Transport  
for NSW

**Minto Resource Recovery Facility (SSD-5339)**

**Issues requiring clarification**

Figure 5 | Heavy vehicle movements

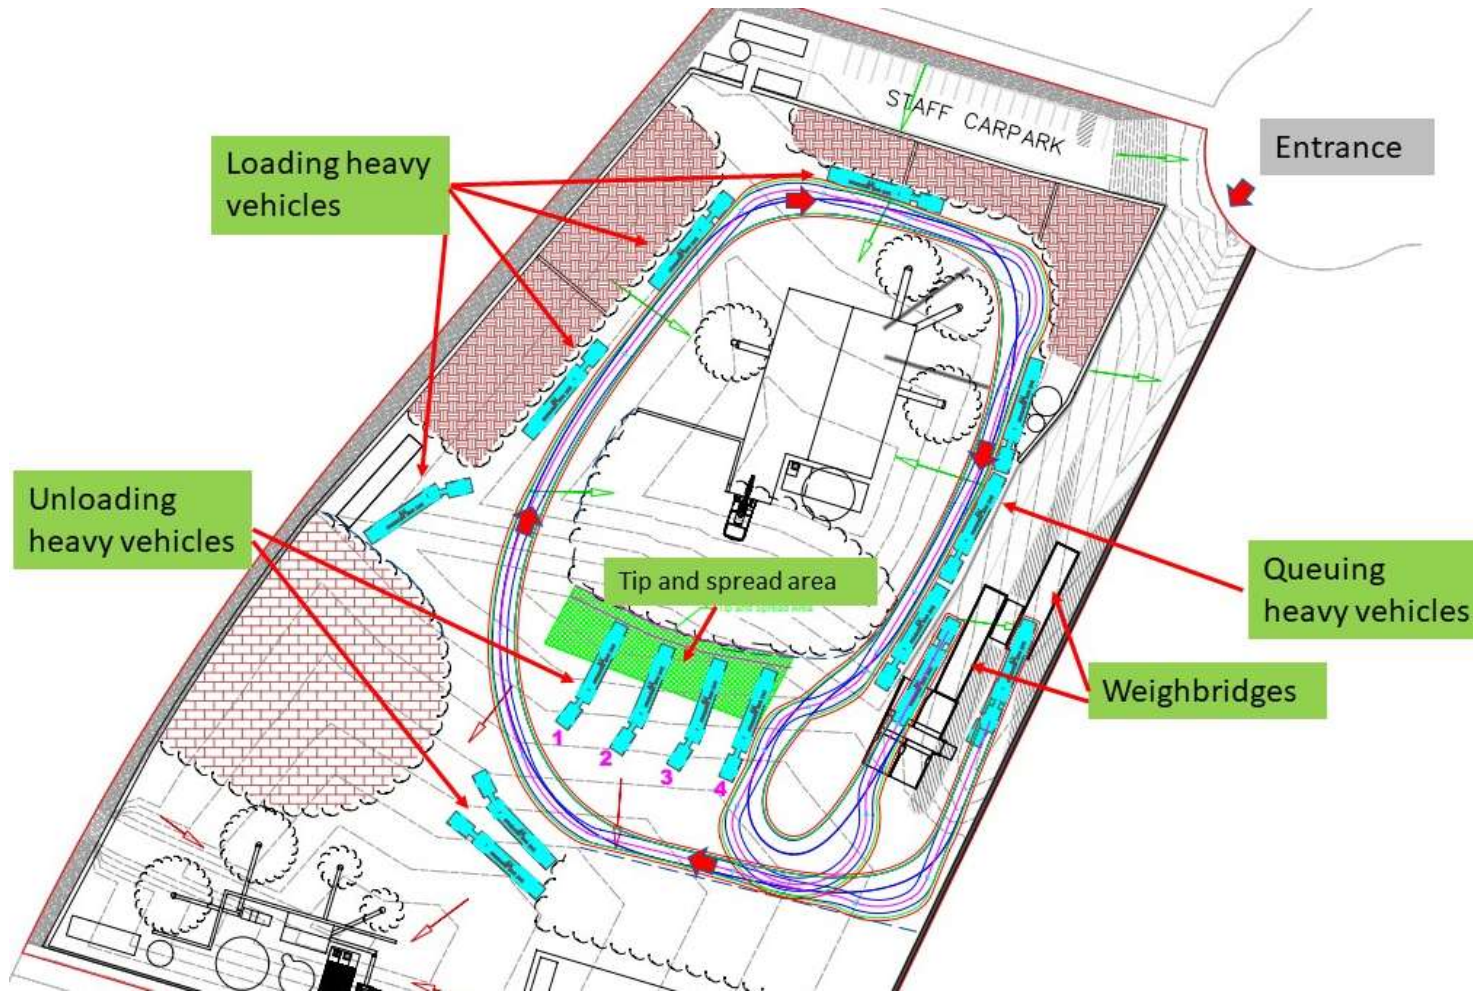
1. The proposed inbound and outbound truck routes indicate that the development traffic would pass through the intersection of Ben Lomond Road/Campbelltown Road. However, this intersection has not been included in the traffic survey/assessment.

DRAWING TITLE				
SWEPT PATH ANALYSIS - SHEET 2 TURNING MANOEUVRE ON SITE				
PROJECT NO.	PLANSET NO.	RELEASE NO.	DRAWING NO.	REVISION
P1203464	PS02	R15	PS02-DZ02	H

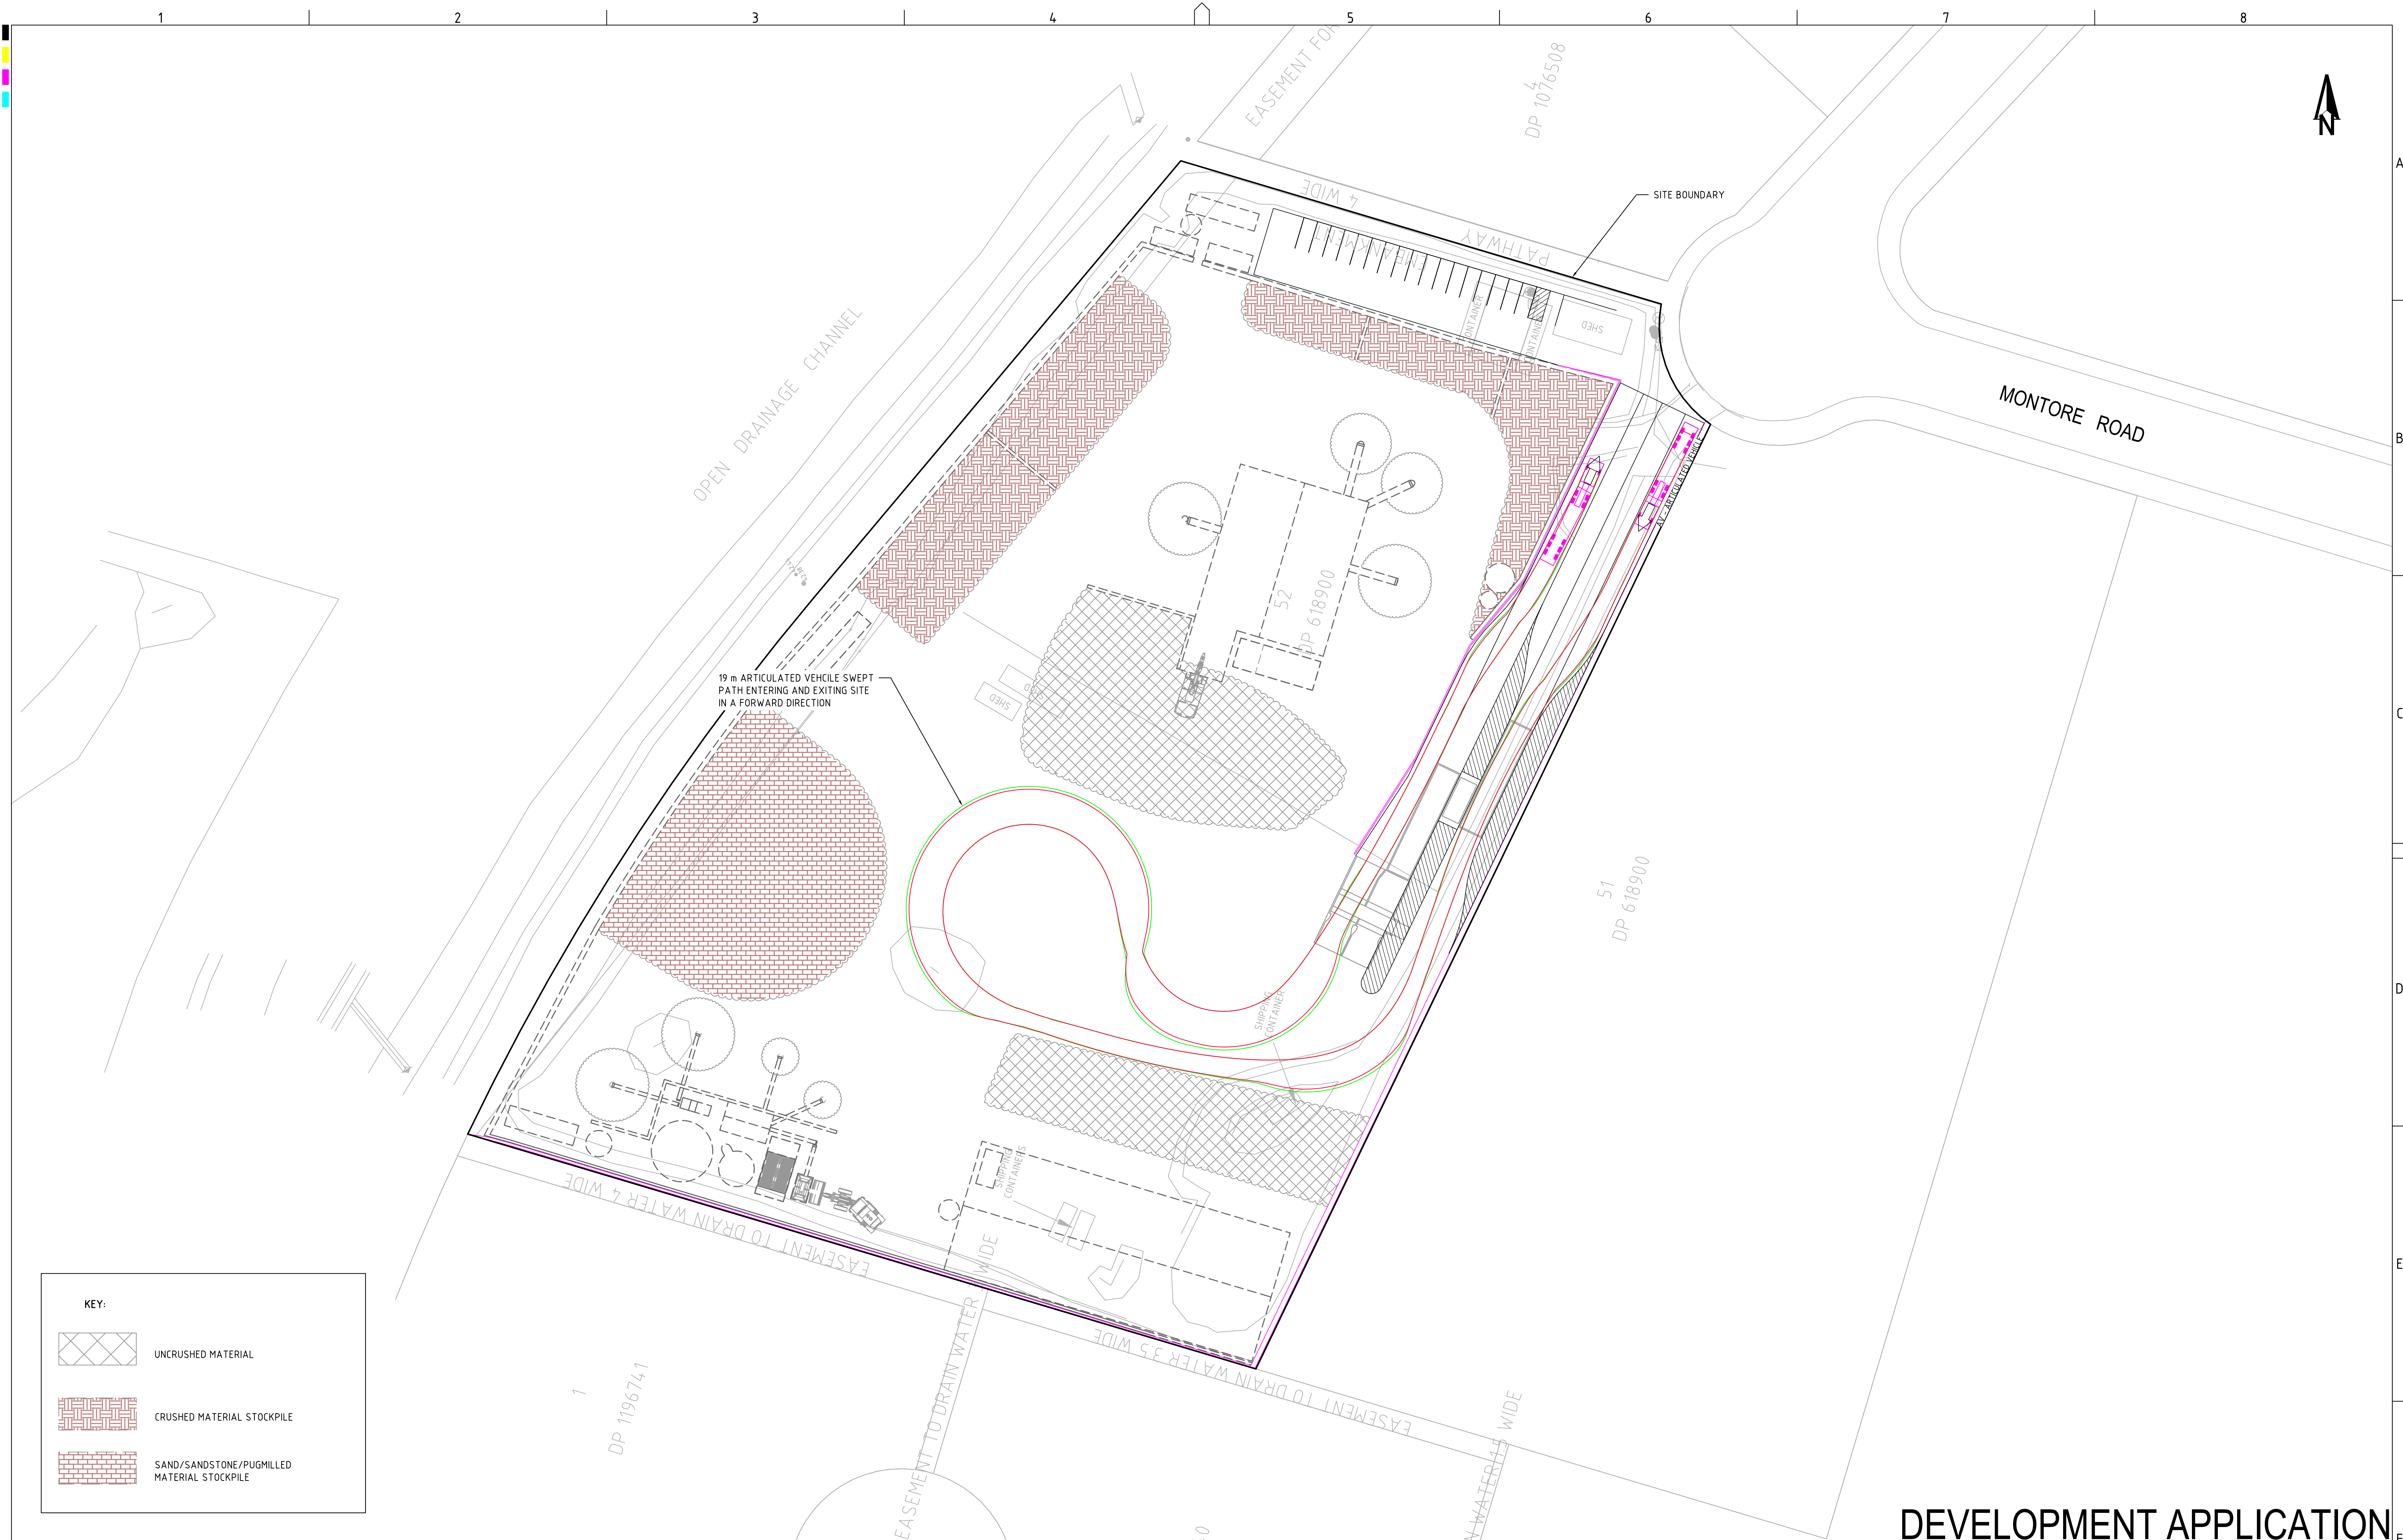
5. The site is located within the approved 25/26m B-Double area, however, the design vehicle for the site is limited to 19m semi-trailer only. The applicant may consider whether the internal road network should be designed to accommodate 25/26m B-Double to improve efficiency.
